Submission to Remediation, Renewal and Adaptive Re-Use of Campbell's Stores, 7 – 27 Circular Quay West, The Rocks, (SSD 7056) – Submission on Behalf of Park Hyatt

THE CAMPBELL WAREHOUSES, THE ROCKS

PEER REVIEW — ACOUSTIC LOGIC CONSULTANCY

Drawing Title  
**SITE PLAN**  
**PROPOSED**  
 JPW Project Number  
**12006**  
 Drawing Status  
**EA**  
 Drawing Number  
**EA-A-002**  
 Revision  
**B**

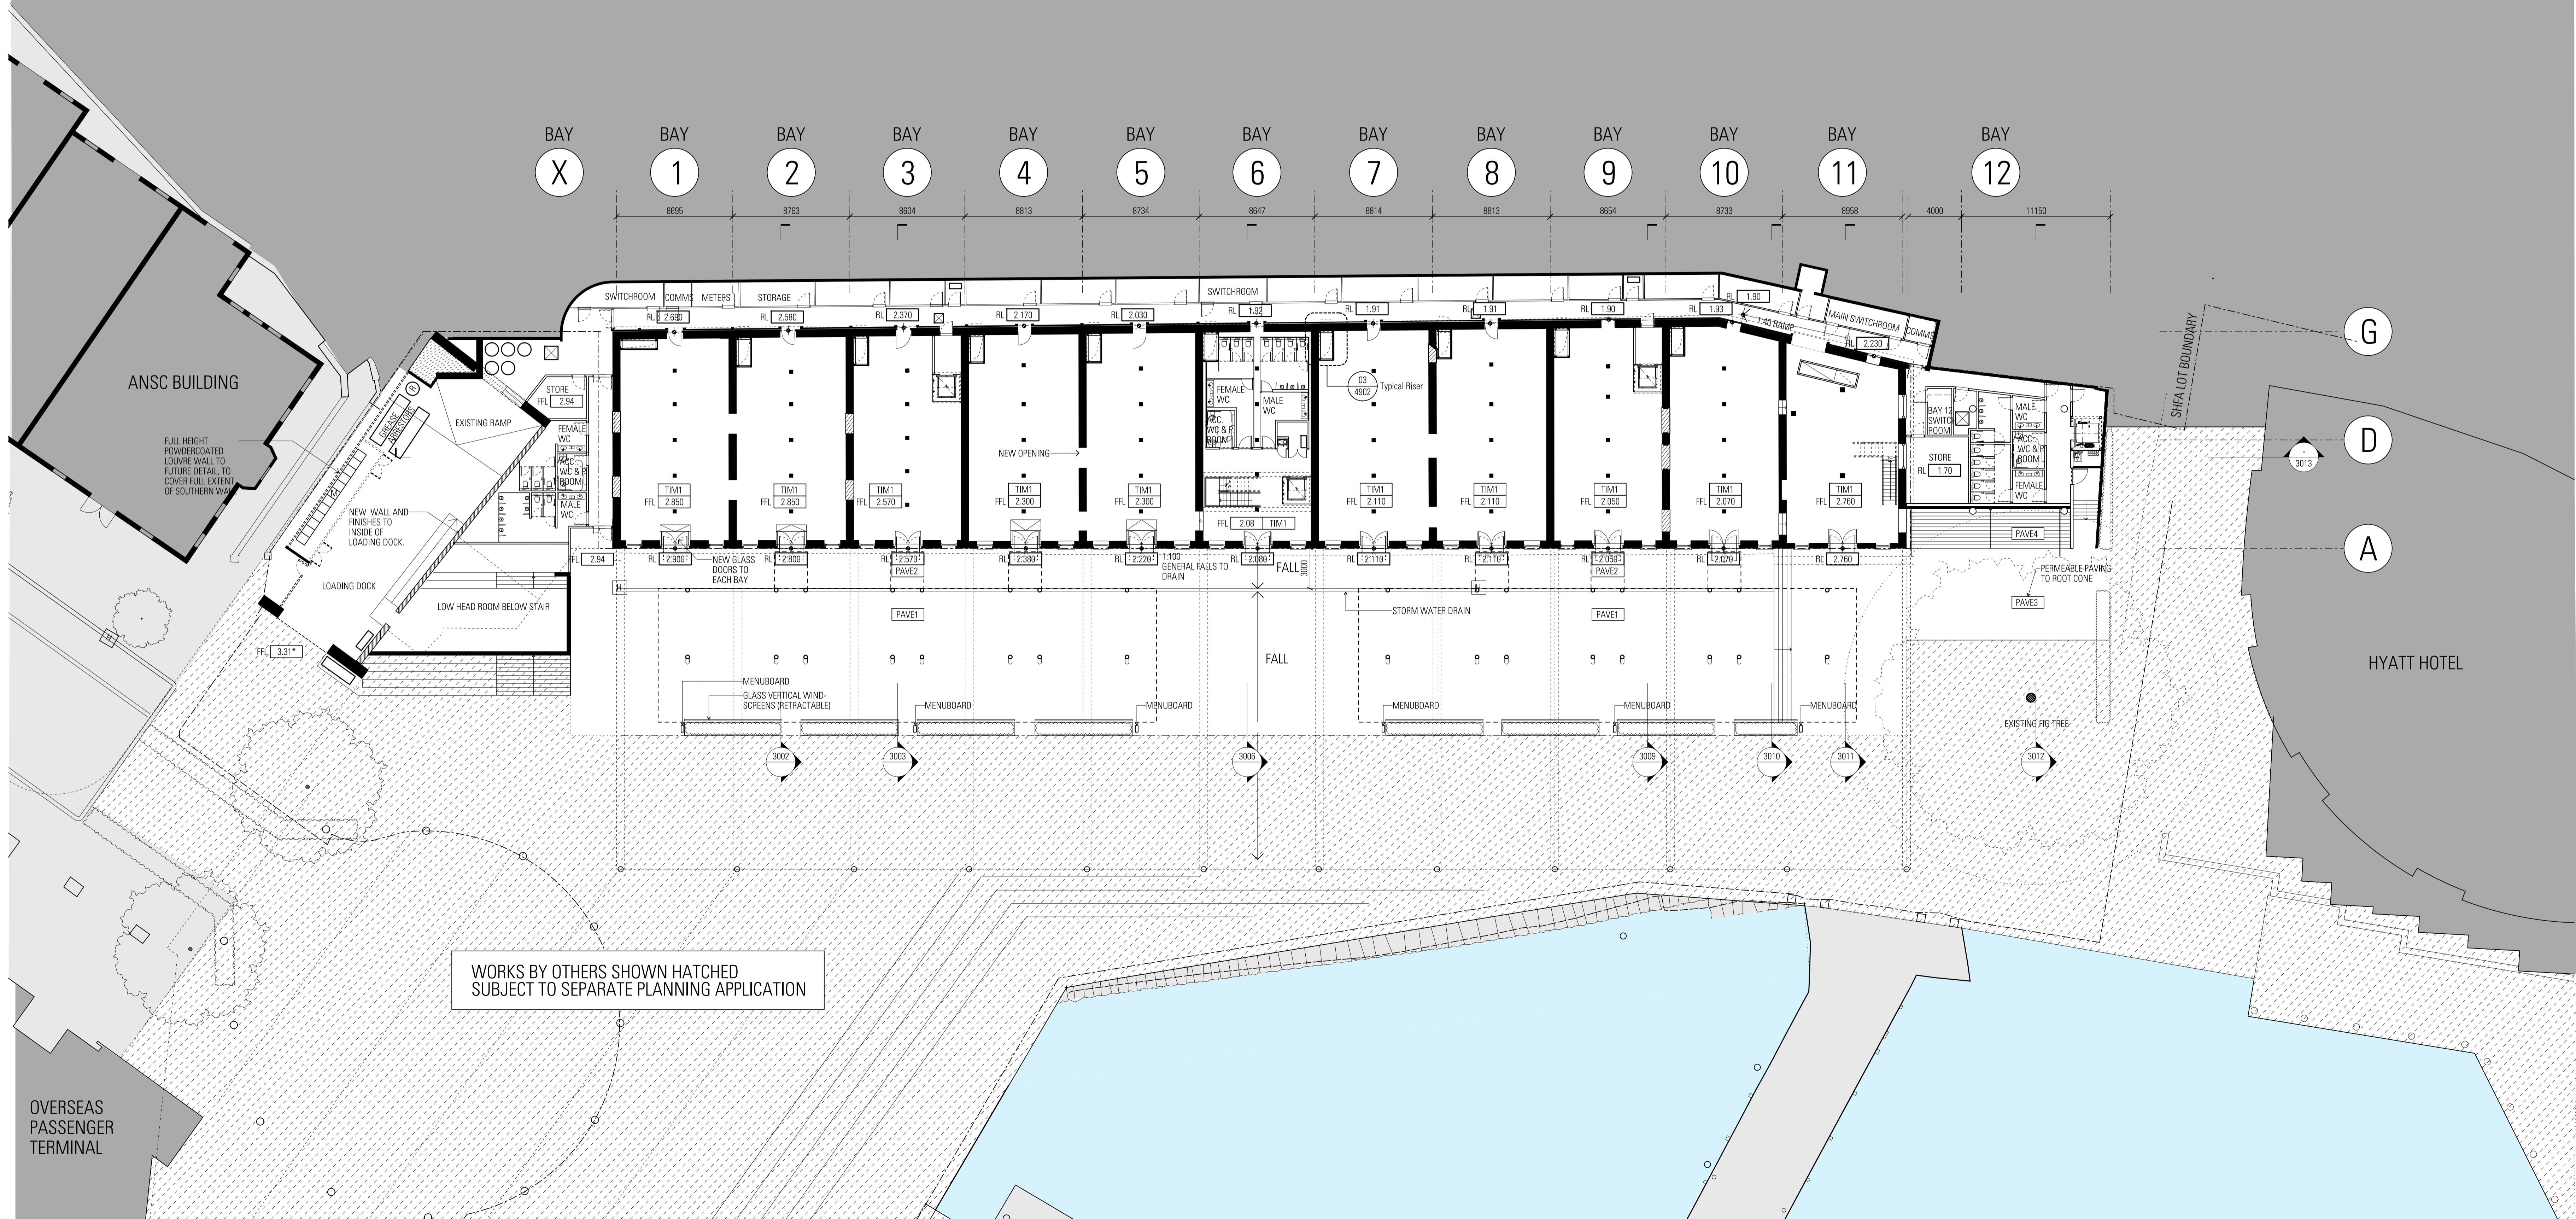
Having reviewed the revised plans and documentation made available, our principal concern is the adverse impact that the new outdoor dining area (Bay 12), with a capacity of approximately 50 people (Dining Area 1), which is proposed to operate between 7am and 12am.

Concern is raised that the use of this space as proposed will have an adverse noise impact on Park Hyatt. Hotel guests will be attempting to sleep during the operating times and if excessive noise impacts occur, their amenity will be adversely impacted.

As shown in **Figure 1** below, the location of outdoor space is in close proximity to the Park Hyatt, with Hotel bedroom’s orientated and looking onto this space.

It is therefore requested that the Department undertakes a further detailed review of potential noise impacts based on the noise report submitted in order to ensure that the amenity of guests of Park Hyatt is protected.
